MARSHALL ENGINEERING SERVICES, PLLC

September 9, 2020

Subject: 163 Chresthaven

I visited your construction site at the above address to review the columns footings and to advise on the septic system.

permit # BRES2004-0011

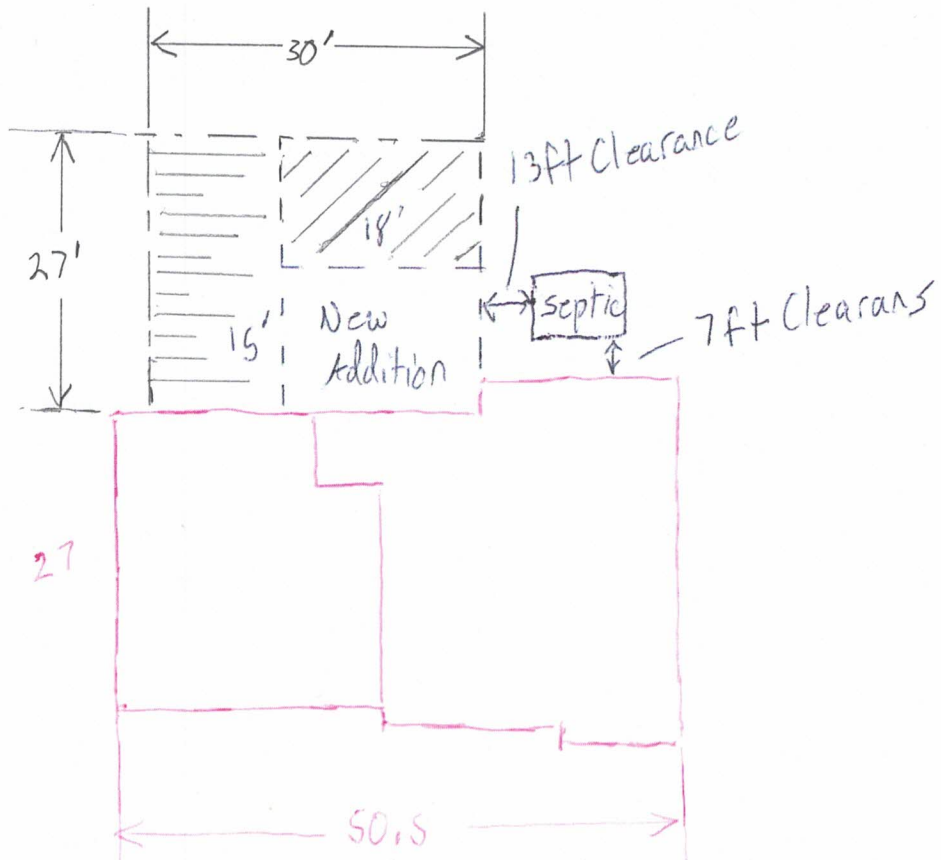
The drawing you provided shows the location of the septic system. The location of the deck construction does not impact the septic system.

ADDATION	165 CRESTHAVEN RD. SANFORD. NC	CONSTRUCTION SOLUTIONS 211 CLAREMONT ST. FAYETTEVILLE, NC	Marshall Engineering Services 7575 McCartans Ford Linden, NC 28356 910-850-5874 Corp. Licenses P0682
FOUNDATION & FRAMING

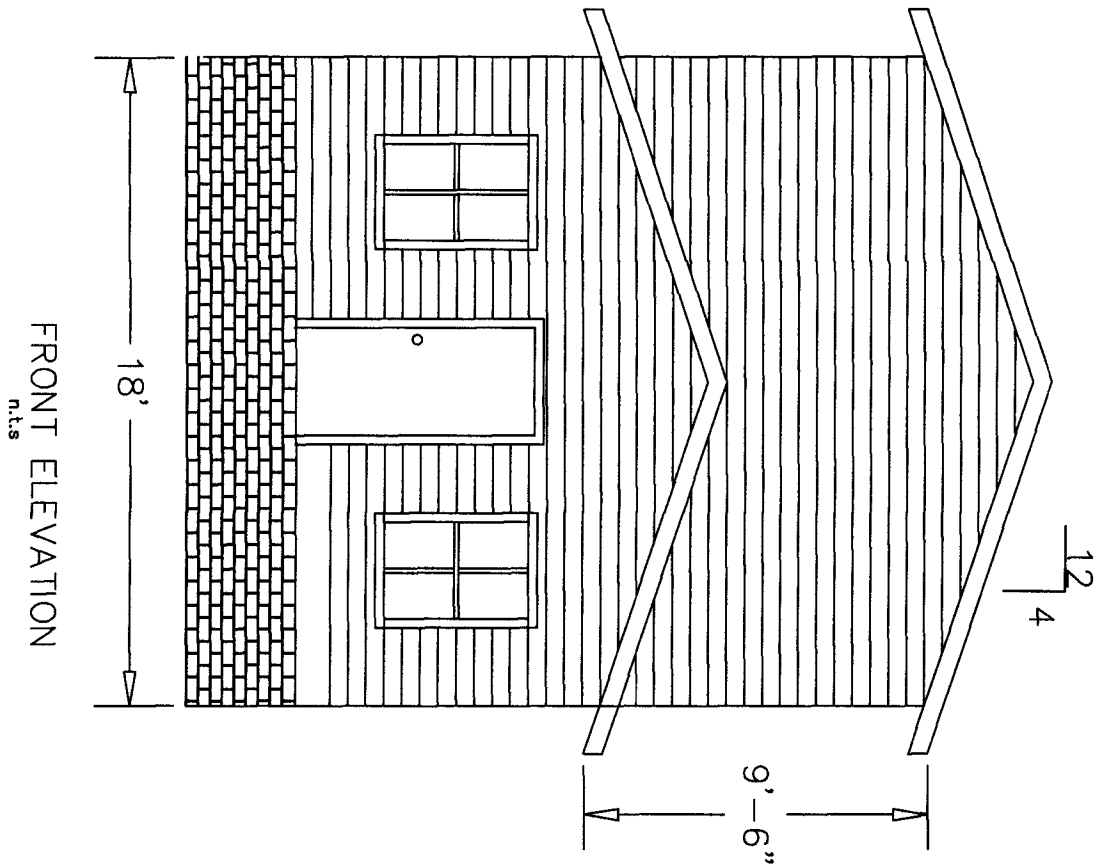
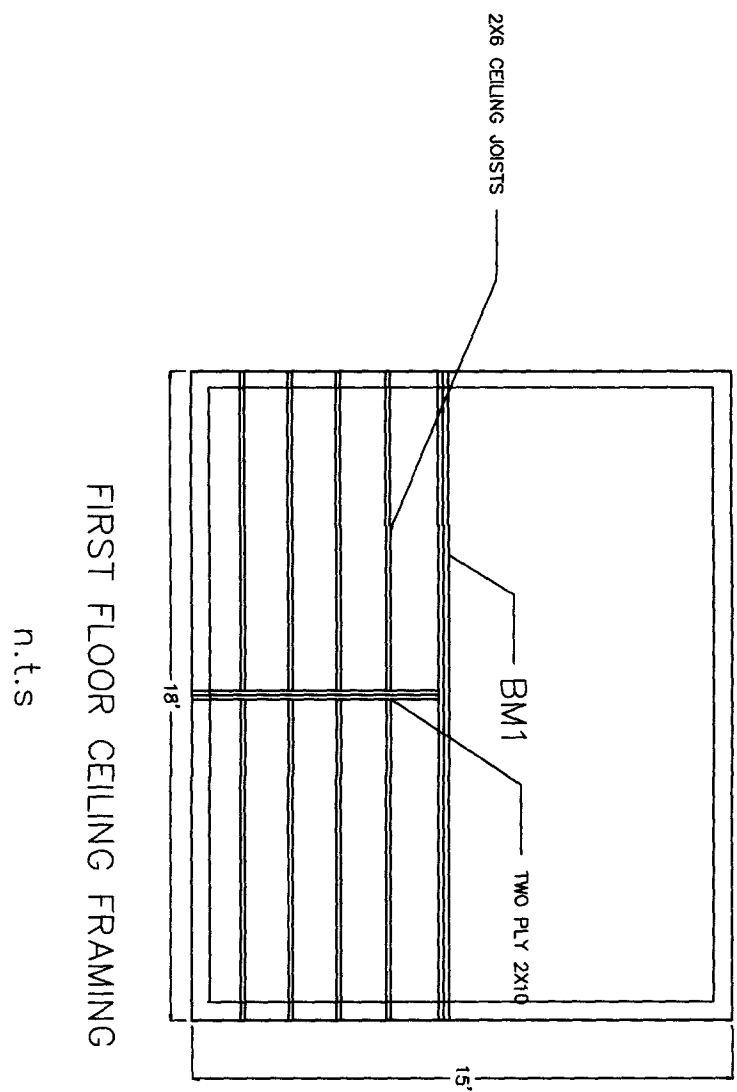
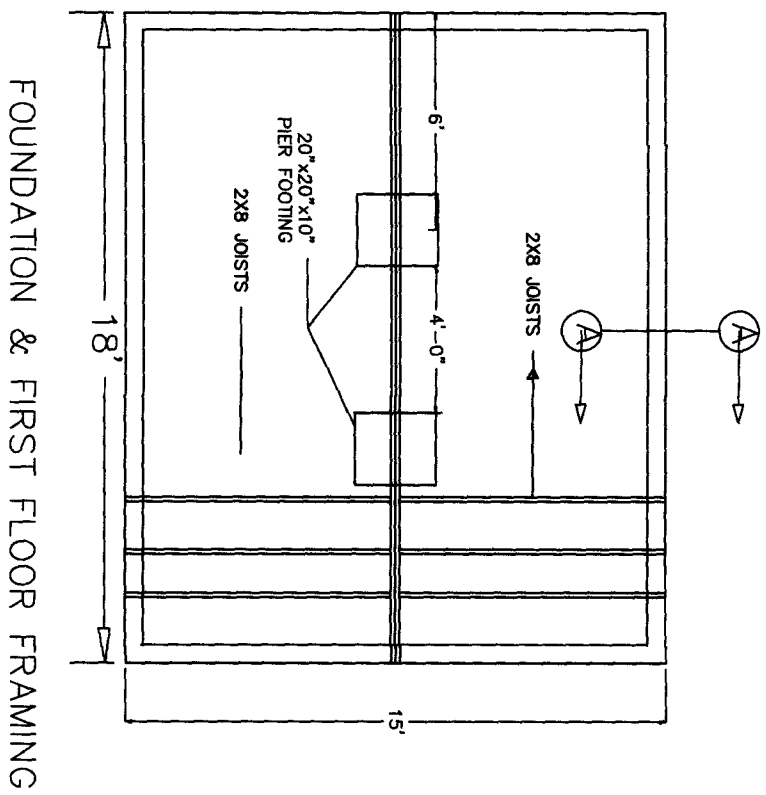
The rim joist is in place, but three columns to rim joist connections need additional fasteners. Each connection must have two ½" bolts. Do not install bolts or structural screws in the space where rim joist butt together. The floor joists are the correct dimensions and material. I recommend you begin installing floor sheathing for the area under roof and decking boards on the open site.

FOOTING DETAILS

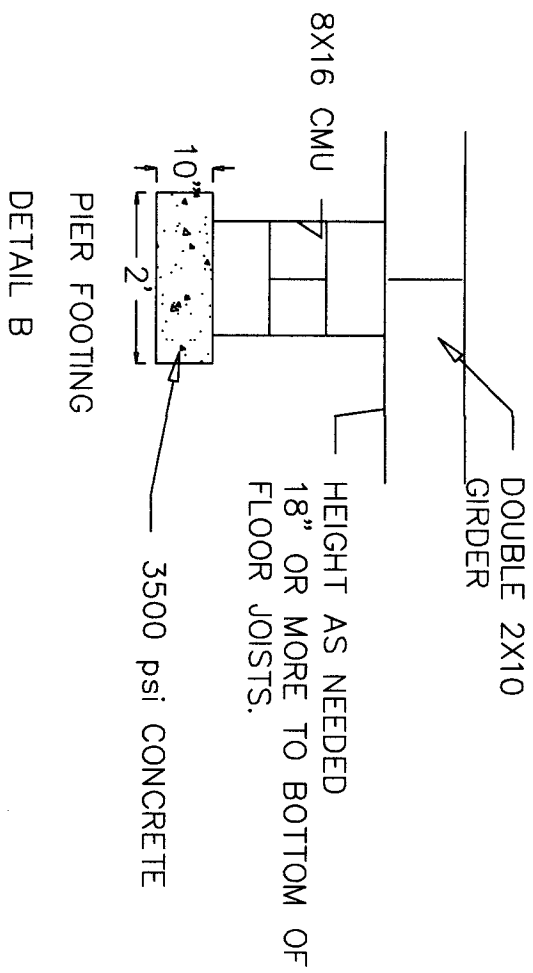
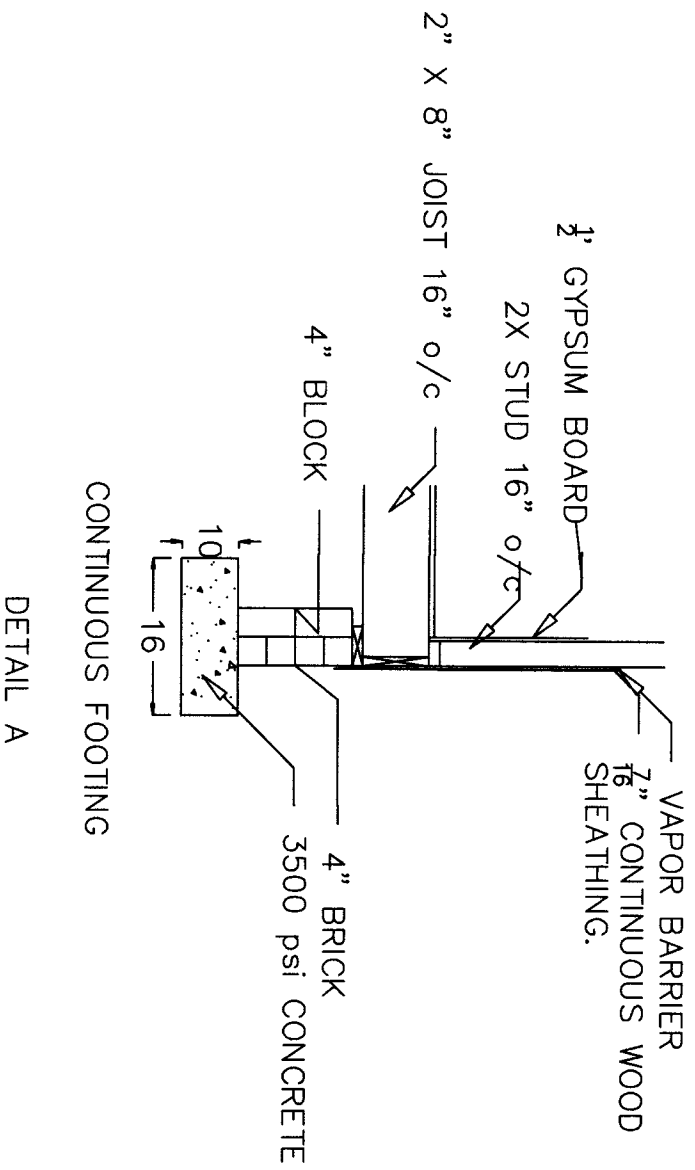
The support columns for the deck are resting on concrete bricks at the bottom of the foundation excavation. The support columns for the guard rails are in their respective holes. These columns encased in concrete will be structurally sound, and I recommend the placement of concrete around these columns.
